**KIRKLEES METROPOLITAN COUNCIL
INVESTMENT & REGENERATION SERVICE**

Reference No:	2025/62/92941/E
Site Address:	High Grove Beds, Headlands Road, Liversedge, WF15 6QA
Description:	Erection of extension to existing trade showroom and new entrance
Recommending Officer:	Edward Cheseldine

DECISION – CONDITIONAL FULL PERMISSION

Officer Report

HGB-PL-002

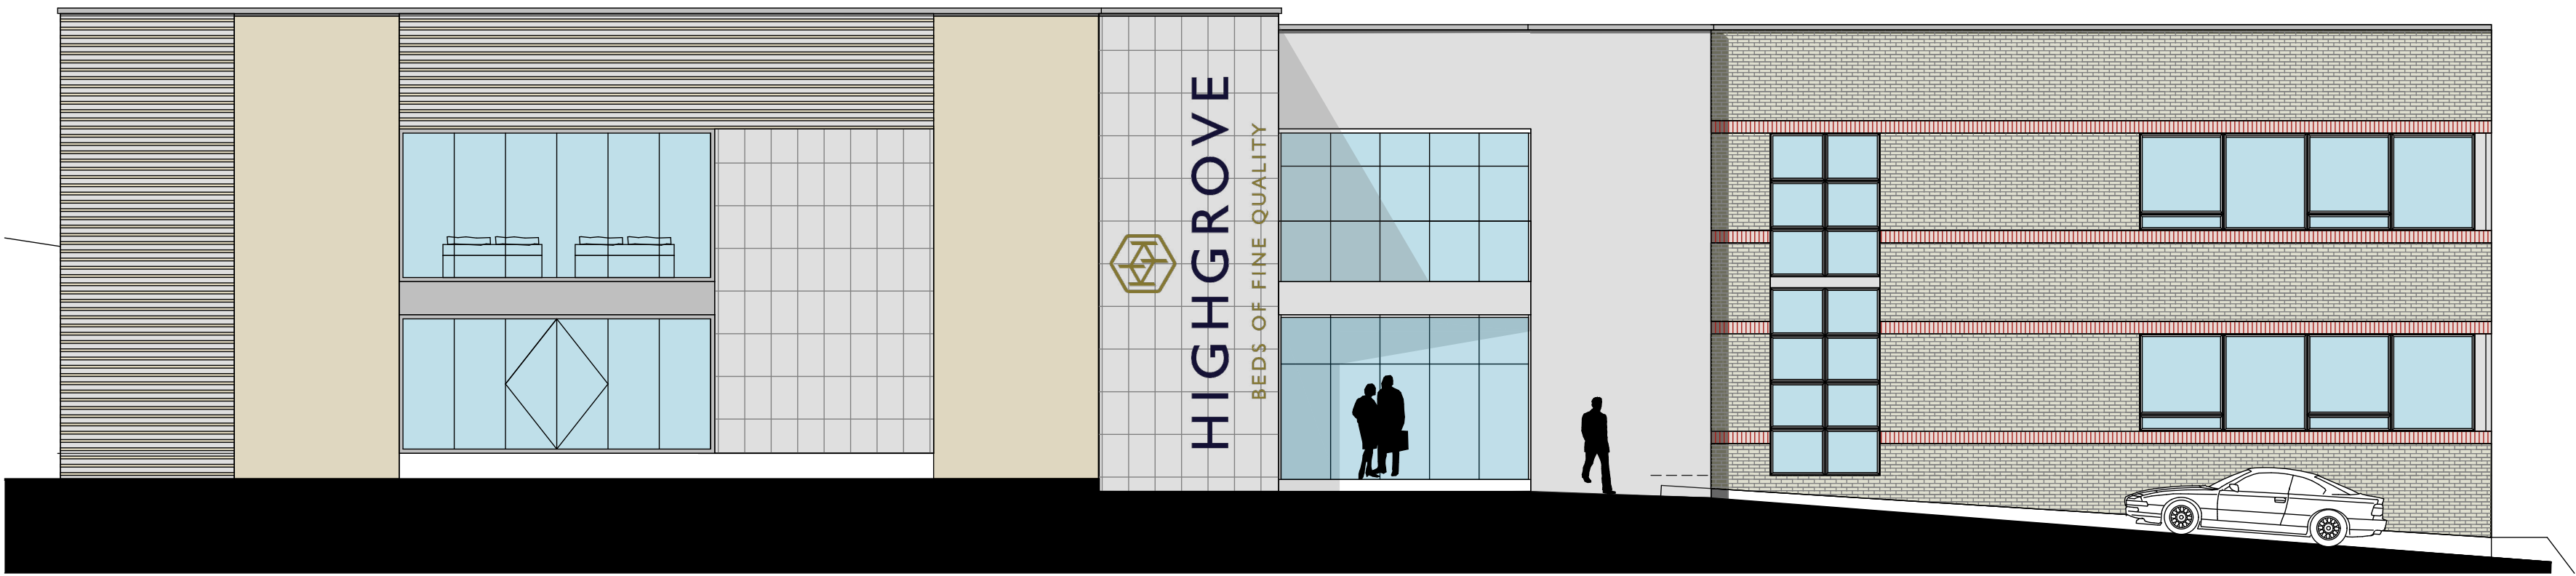
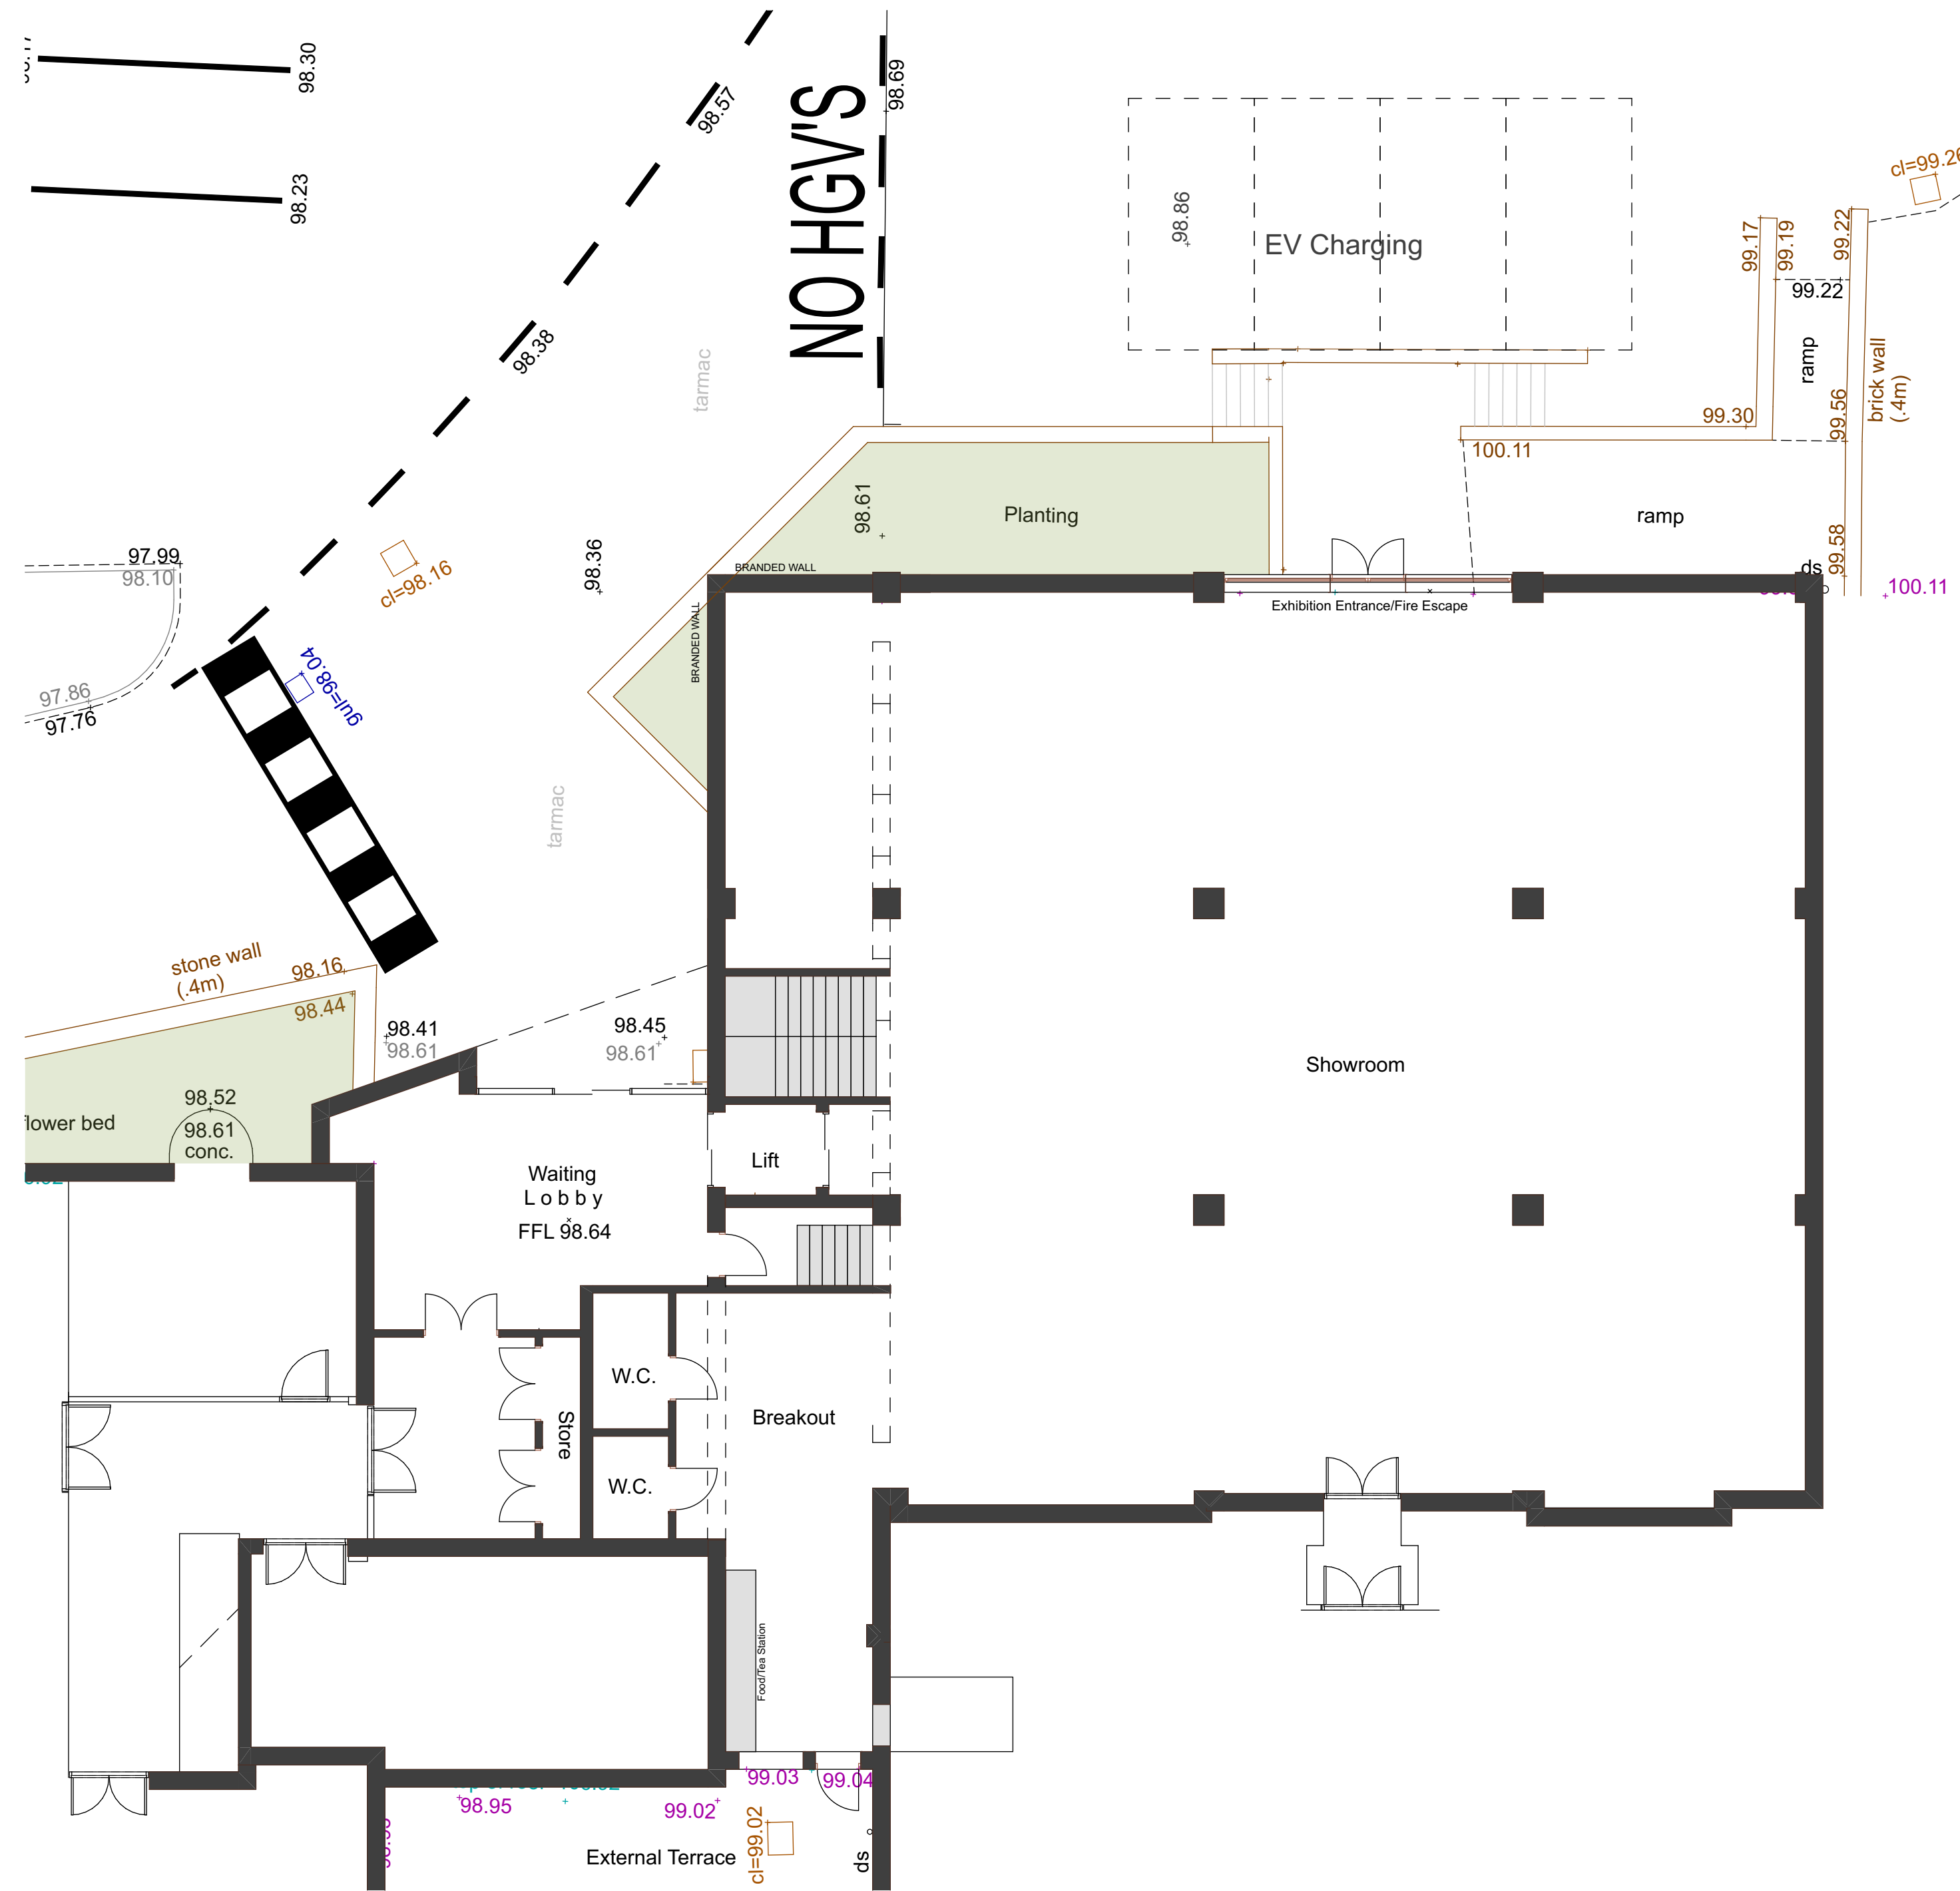
Officers requested the details of the external materials including the colour and materials over the course of the decision-making process, however these were not received.

The proposed development introduces cladding within a section of the building. However, further details have not been provided. The extent of external alterations is currently unclear and there are several material changes on the proposed plans indicated which appear to be formed of other materials, therefore it is recommended that the colour and external materials are submitted and secured by condition. This is worded to avoid being pre-commencement.

3. Notwithstanding the submitted plans, prior to development of the superstructure of the extension hereby approved, details of the external materials including colour and materials shall be submitted to and approved in writing by the Local Planning Authority. Thereafter the development shall be completed using the approved materials and retained as such.
Reason: In the interests of visual amenity and to comply with Policy LP24 of the Kirklees Local Plan and Chapter 12 of the National Planning Policy Framework.

GROUND FLOOR PLAN 1:100

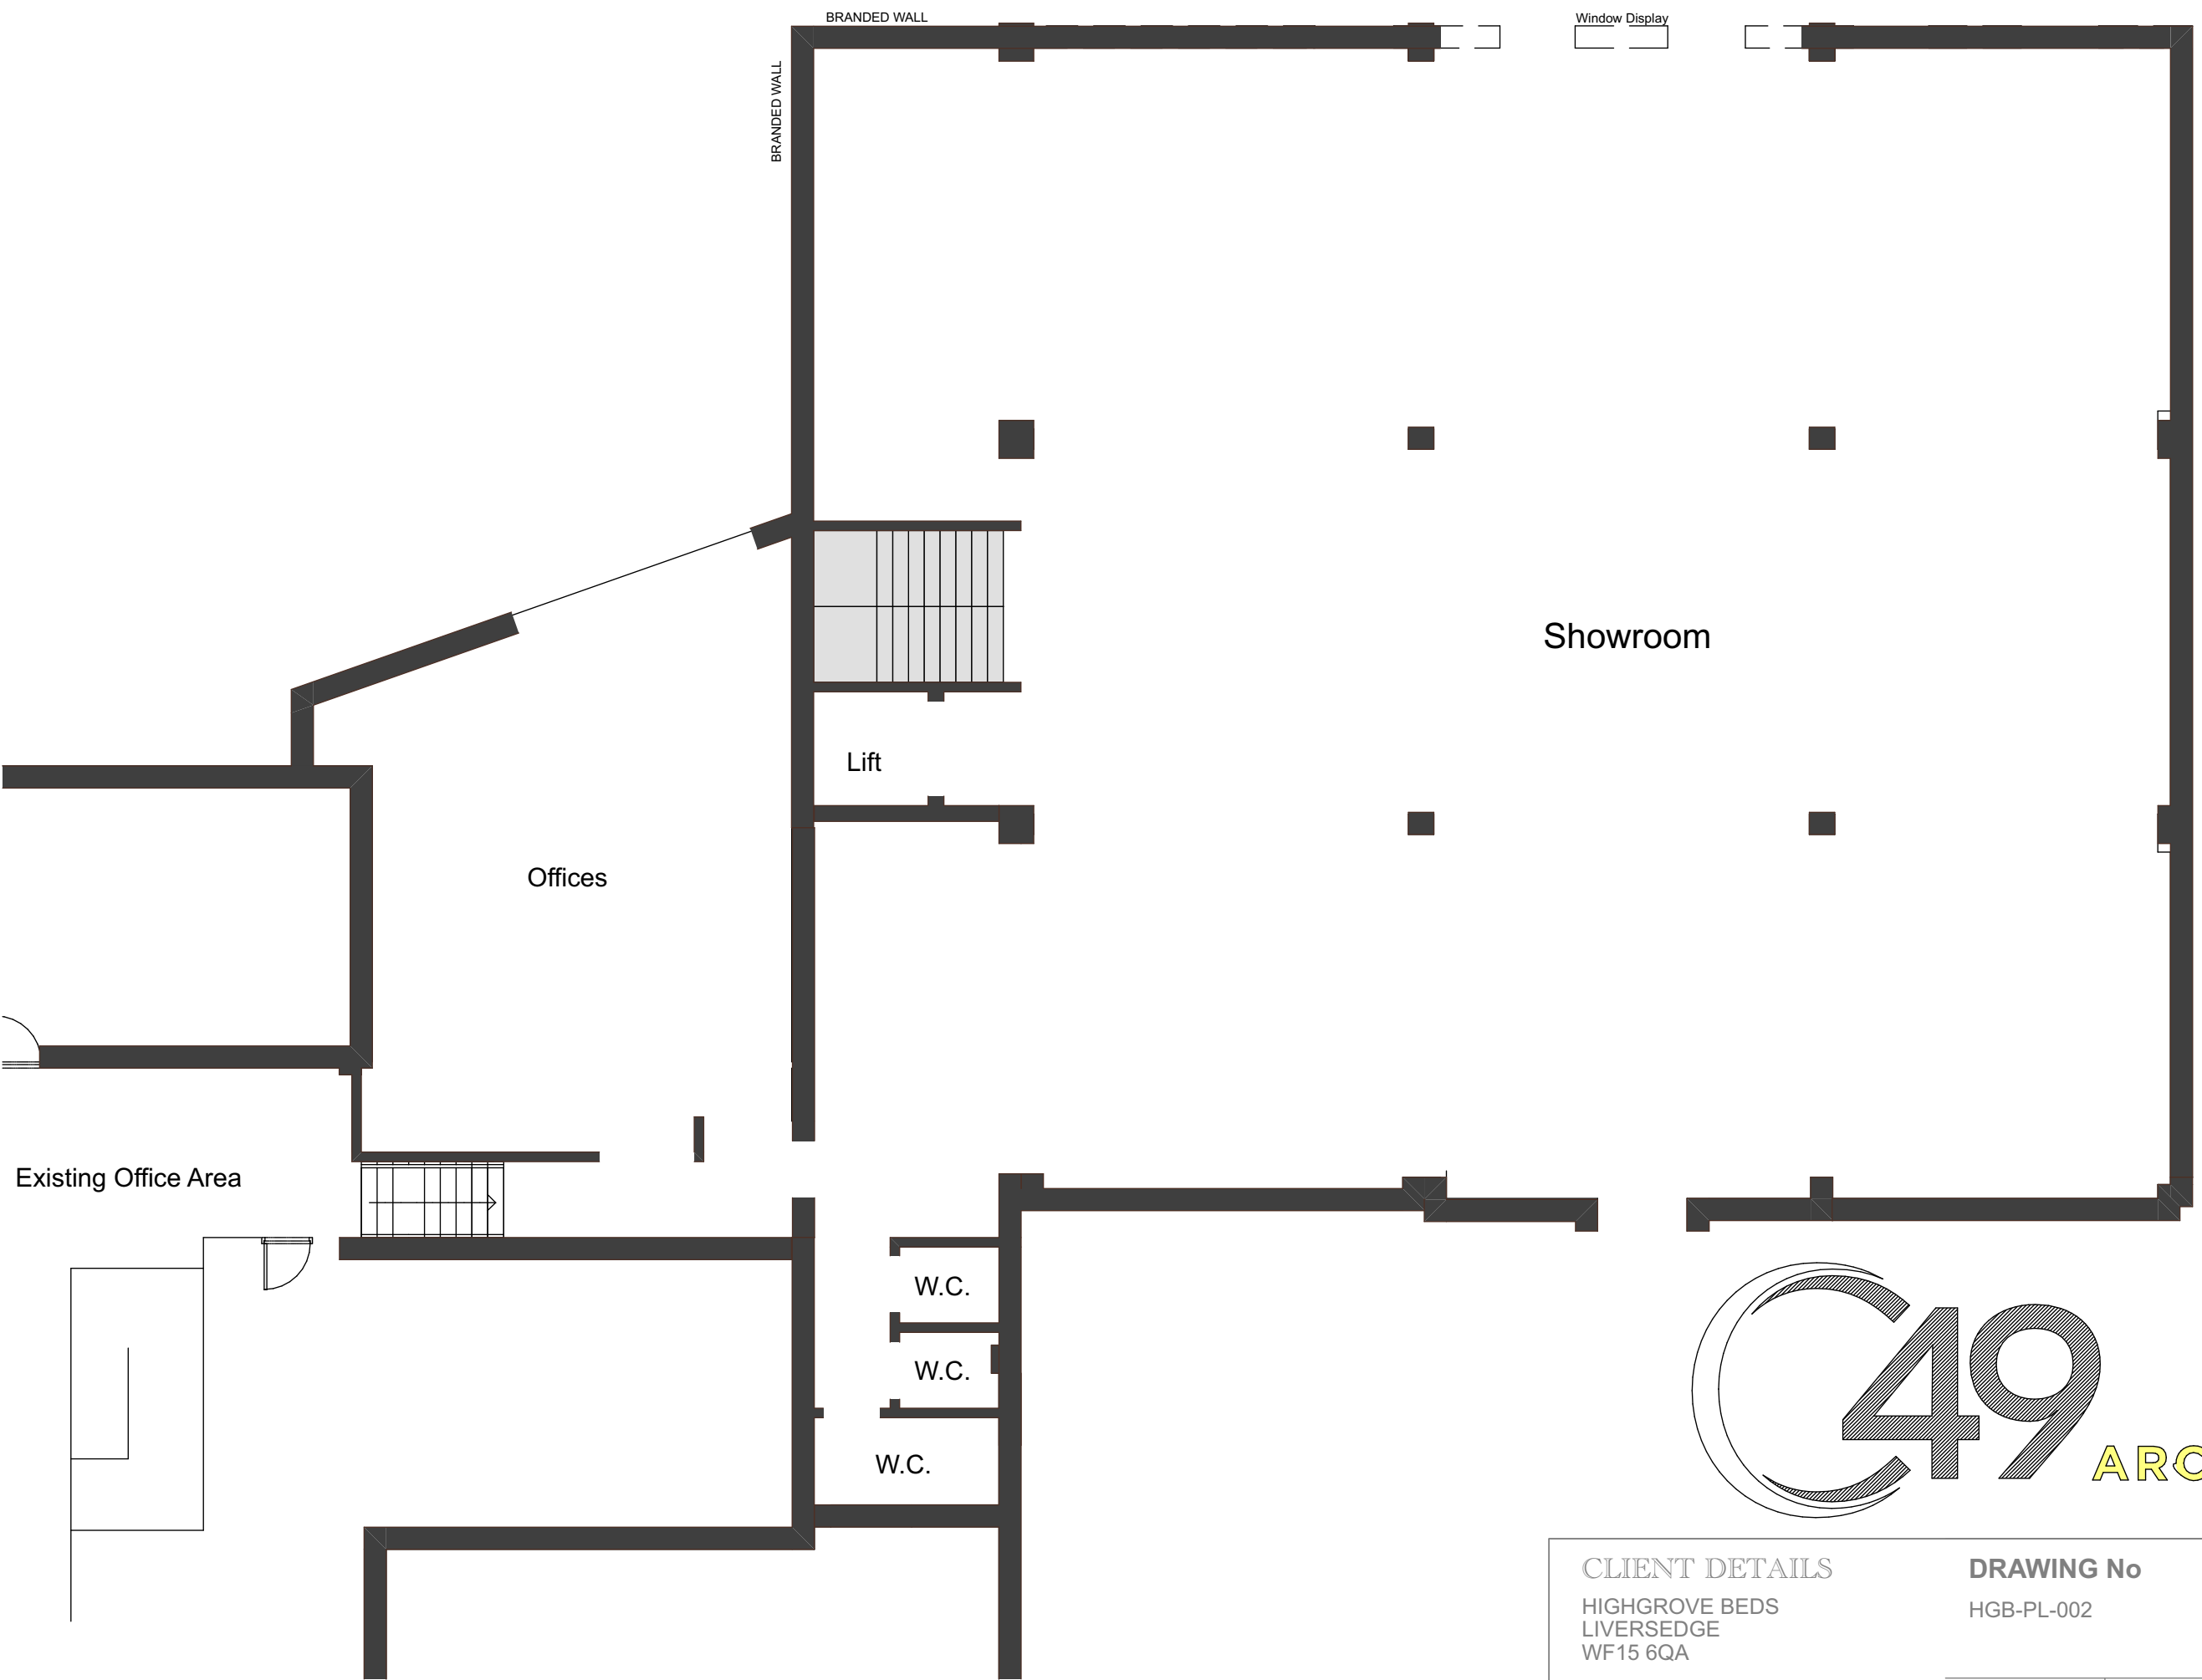
Plans will introduce a further stepped access and reconfiguration of an access ramp. The main entrance will be levelled which is a suitable alteration to provide access.
